Applicant: Morley Stores

Proposal: Discharge of Conditions 10 (vehicular electric charging points) and 11 (provision of solar PV) of 20/02139/F

DATE: 7 March 2022

drawing title: **SITE LAYOUT PLAN AS PROPOSED**

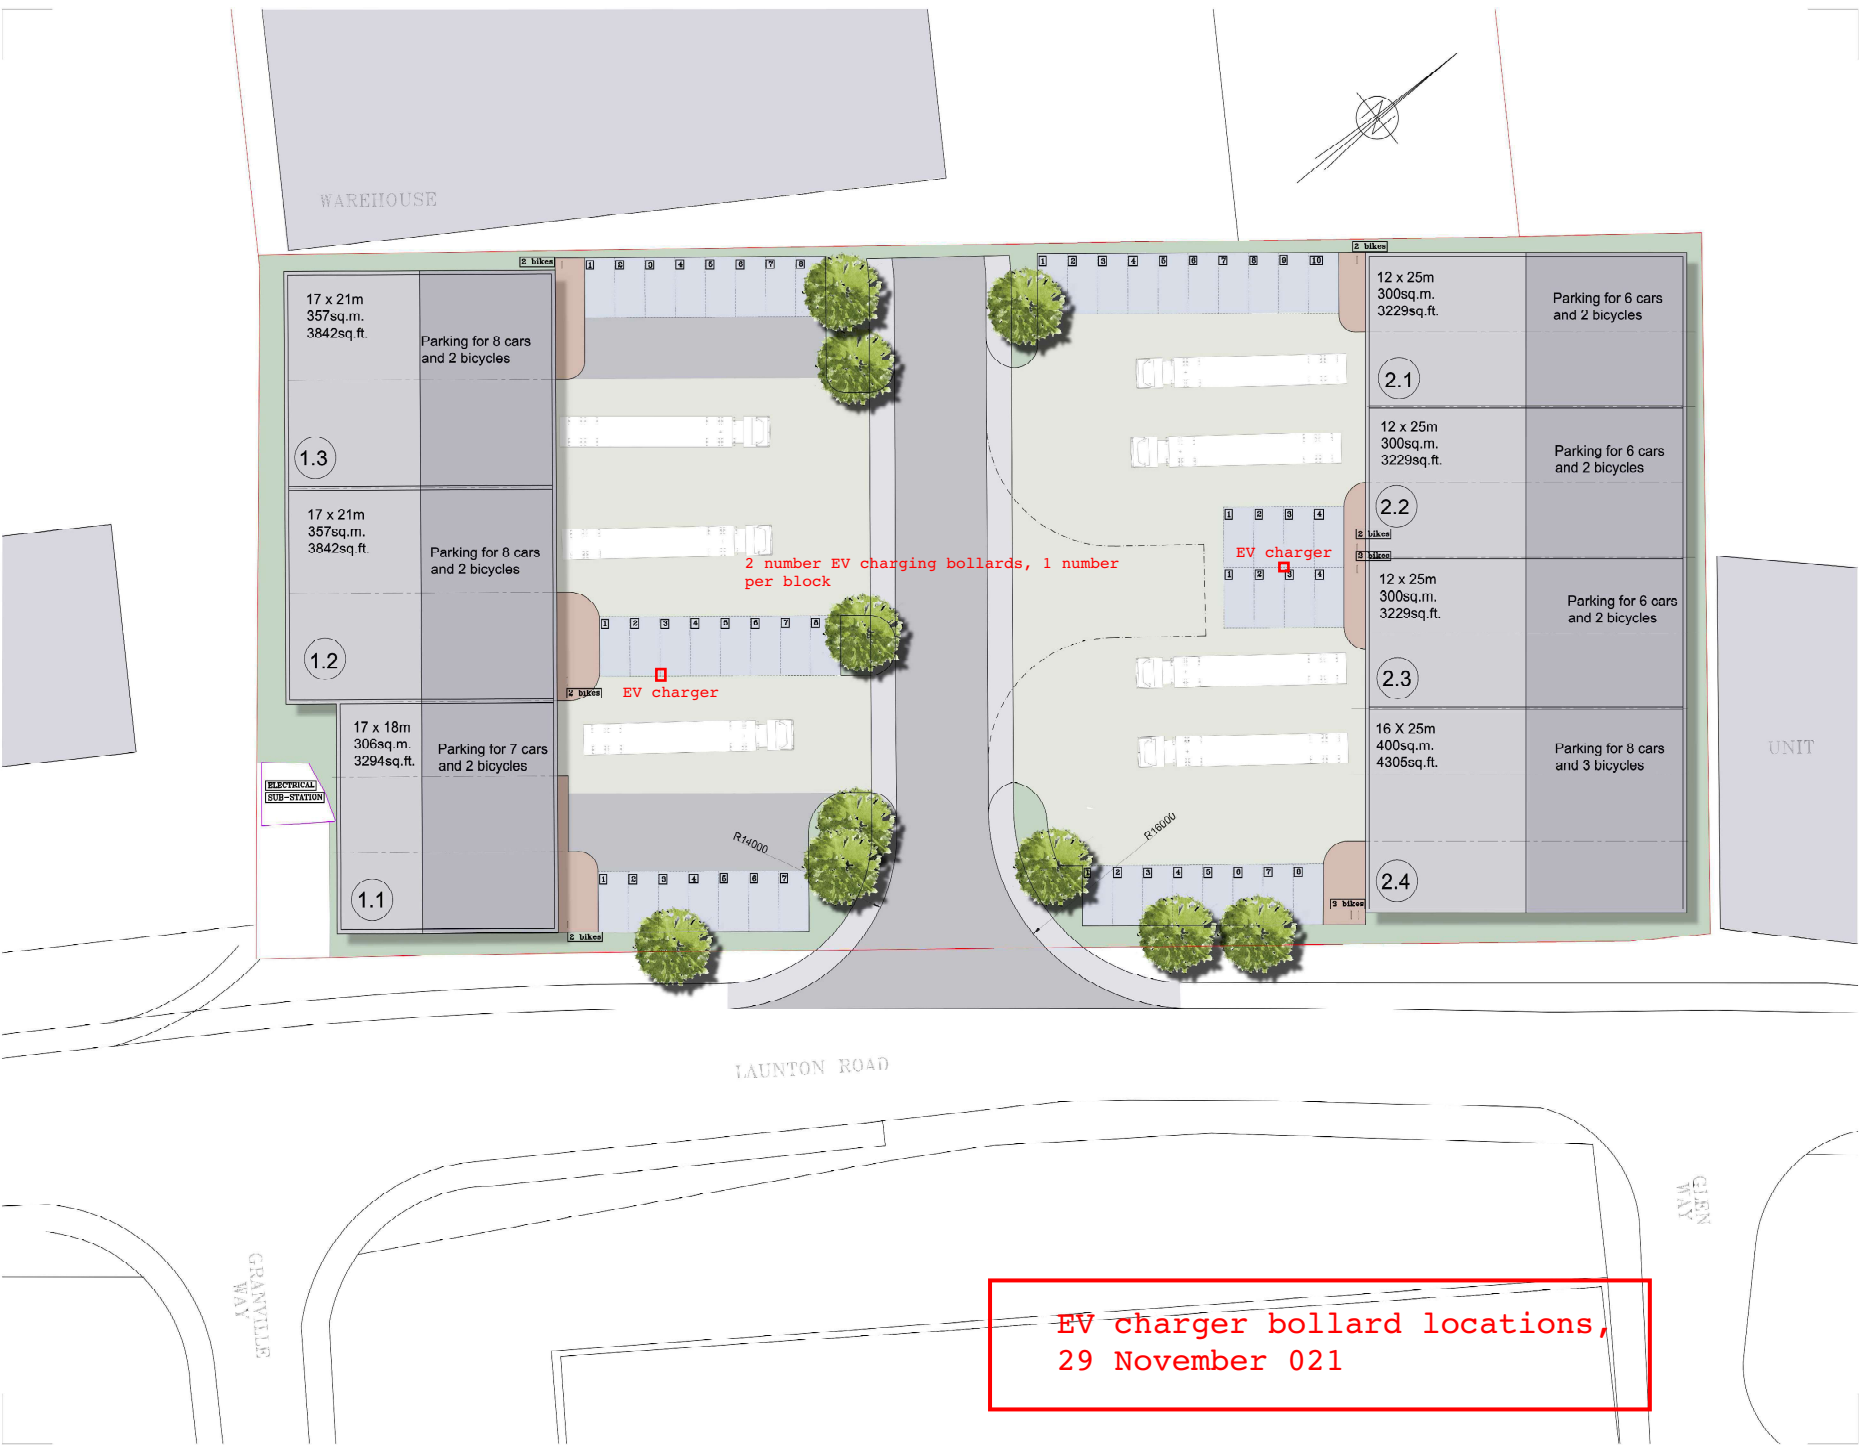
- 5.1. Condition 10 – The condition requires a scheme for vehicular electric charging points to be submitted for the development. The submitted drawings show the location of two charging points (one to serve each block of units).

The Council's Environmental Protection Officer has advised that this is adequate although they would have ideally liked one per unit. In response to the comments, the agent has confirmed (email dated 07/03/2022) that ducting has been installed in the car parking areas to allow future EV charging points to be readily installed.

Drawing number 210,34-51 Rev B – [Site Layout Plan as Proposed] and agent email (dated 07 March 2022) confirming the installation of ducting within the car parking area.

SITE: C510  
 BICESTER  
 TITLE: 201 PV LAYOUT

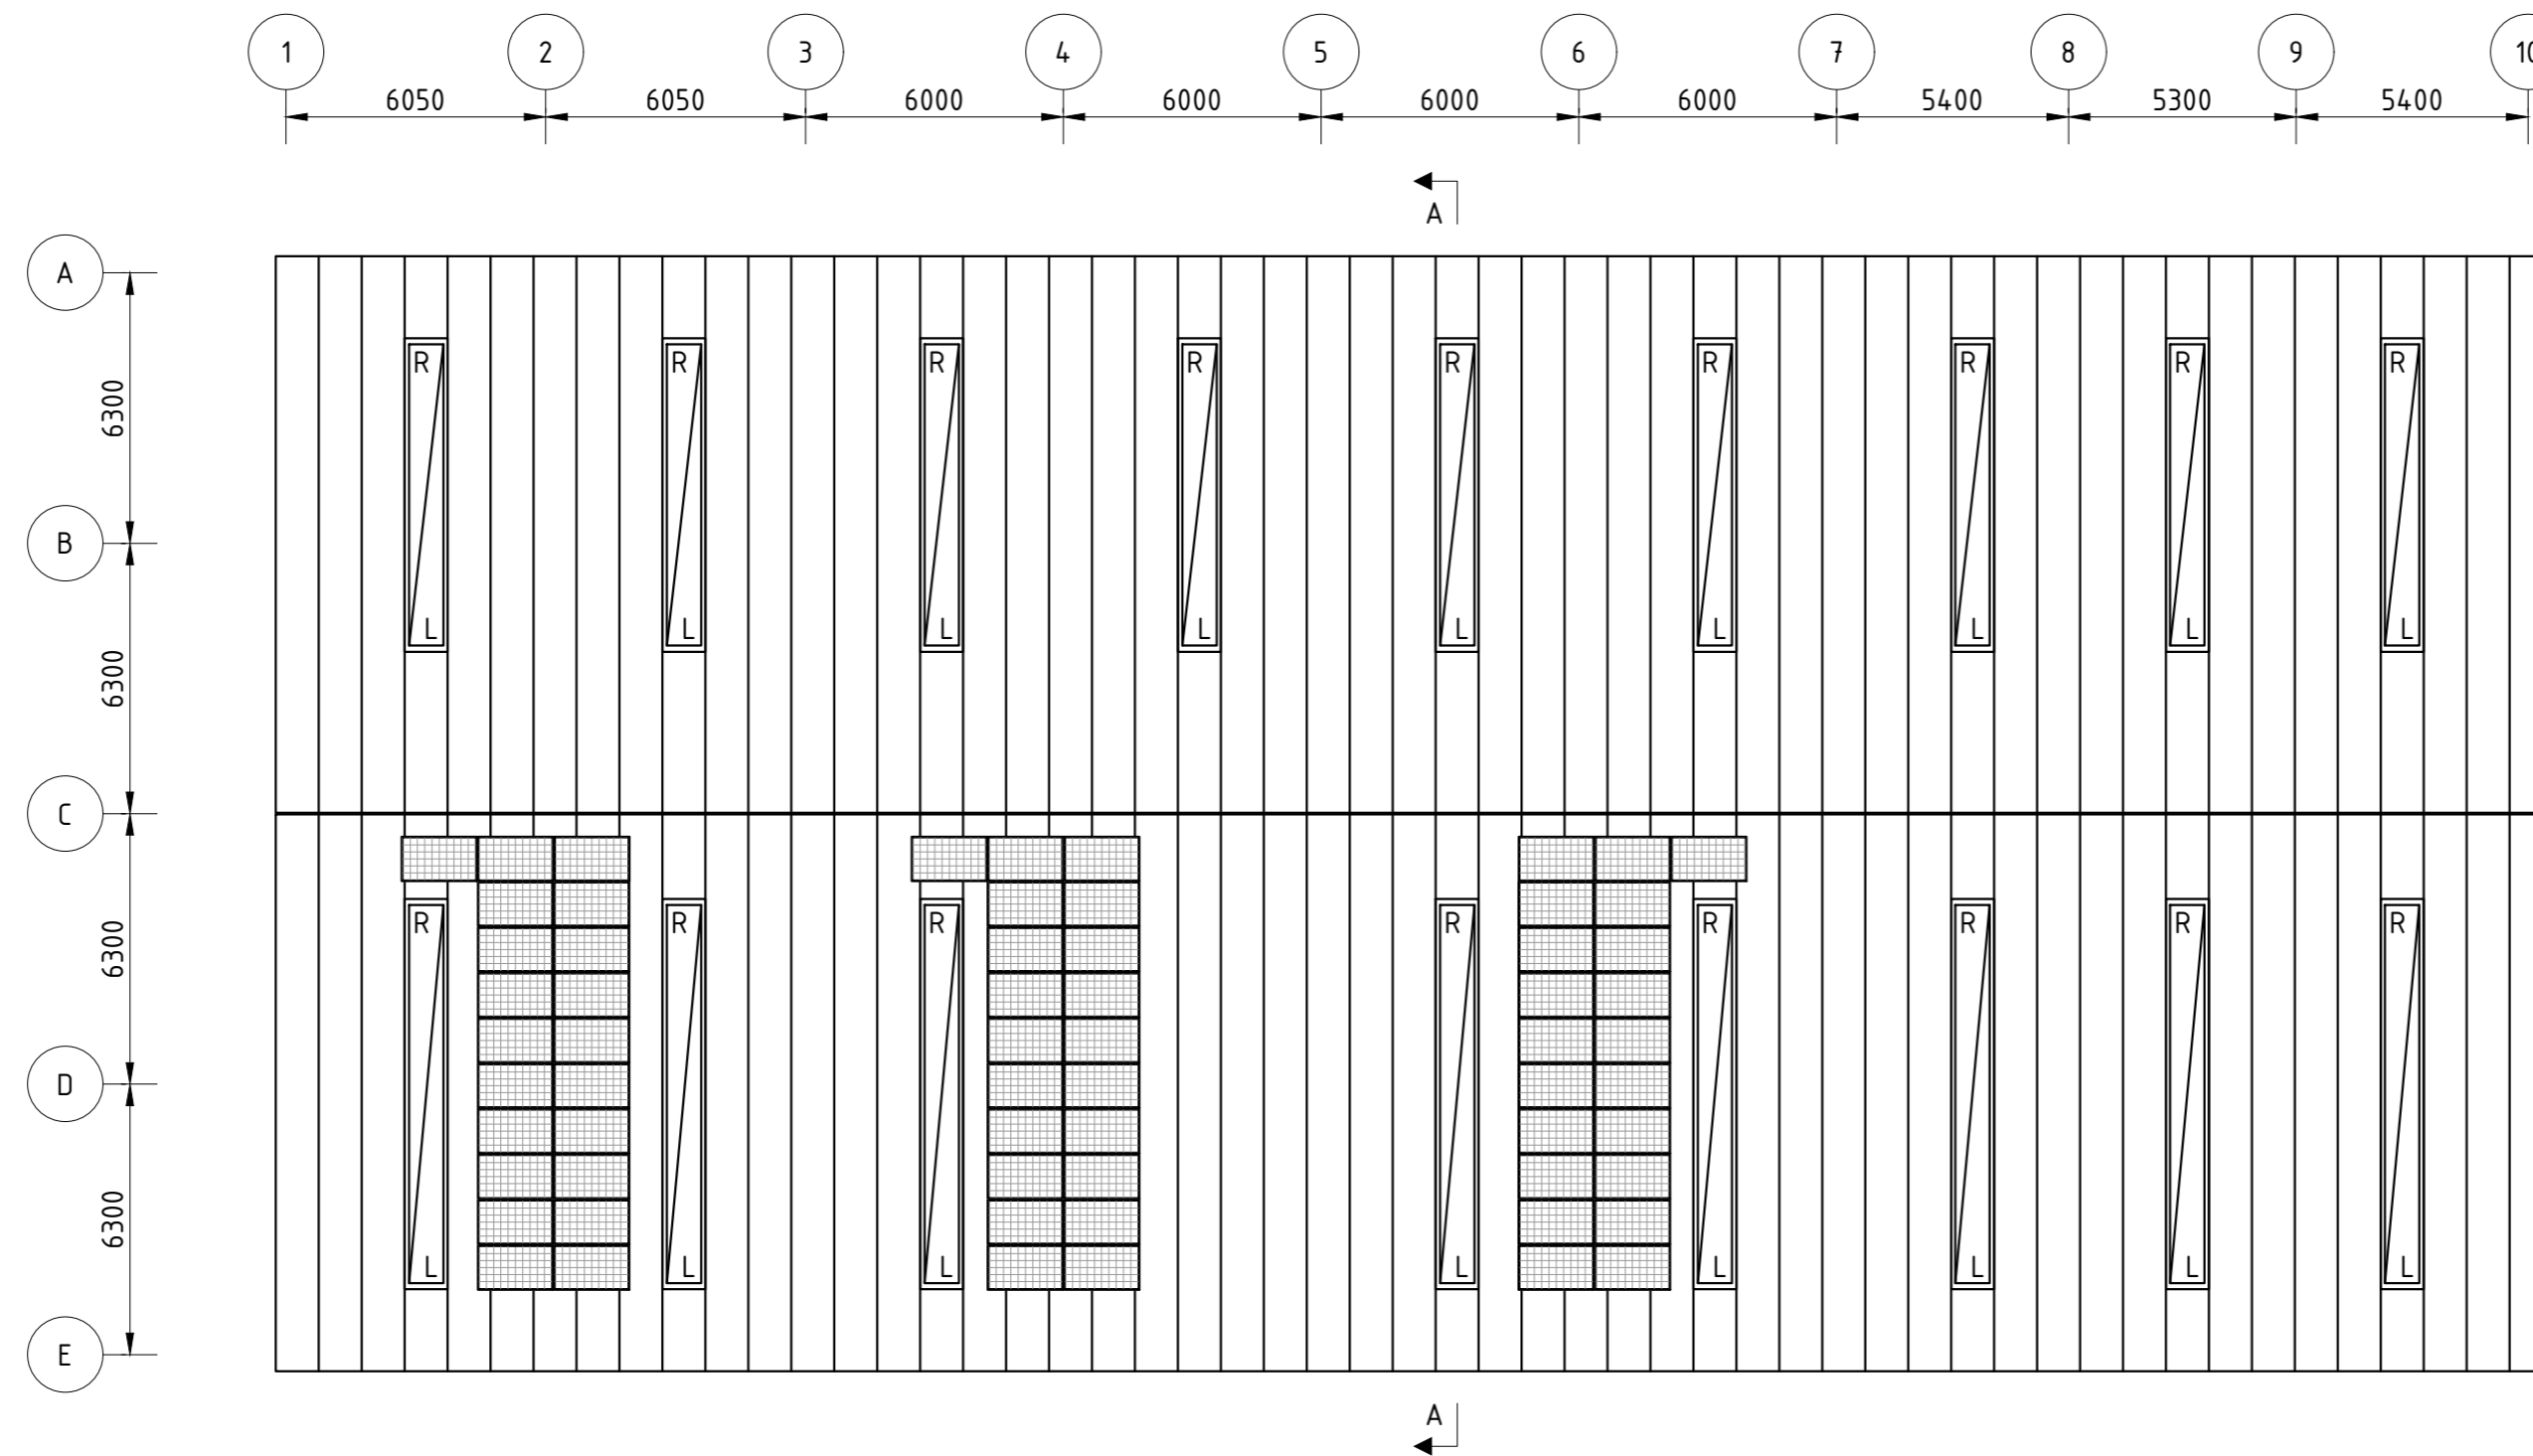
- 5.2. Condition 11 – The condition requires the submission of a scheme for the installation of solar panels. The applicant has submitted a 'PV Justification Statement' setting out the volume of panels that can be accommodated and an accompanying roof plan to show the location of the proposed panels.

The details of the proposed solar panels are considered to be sufficient, and the condition is recommended to be discharged.

PV Justification Statement (C510 – Bicester Revision B) produced by Energist UK, dated 28th October 2021 and drawing number A2/183 Rev A – [201 PV Layout].
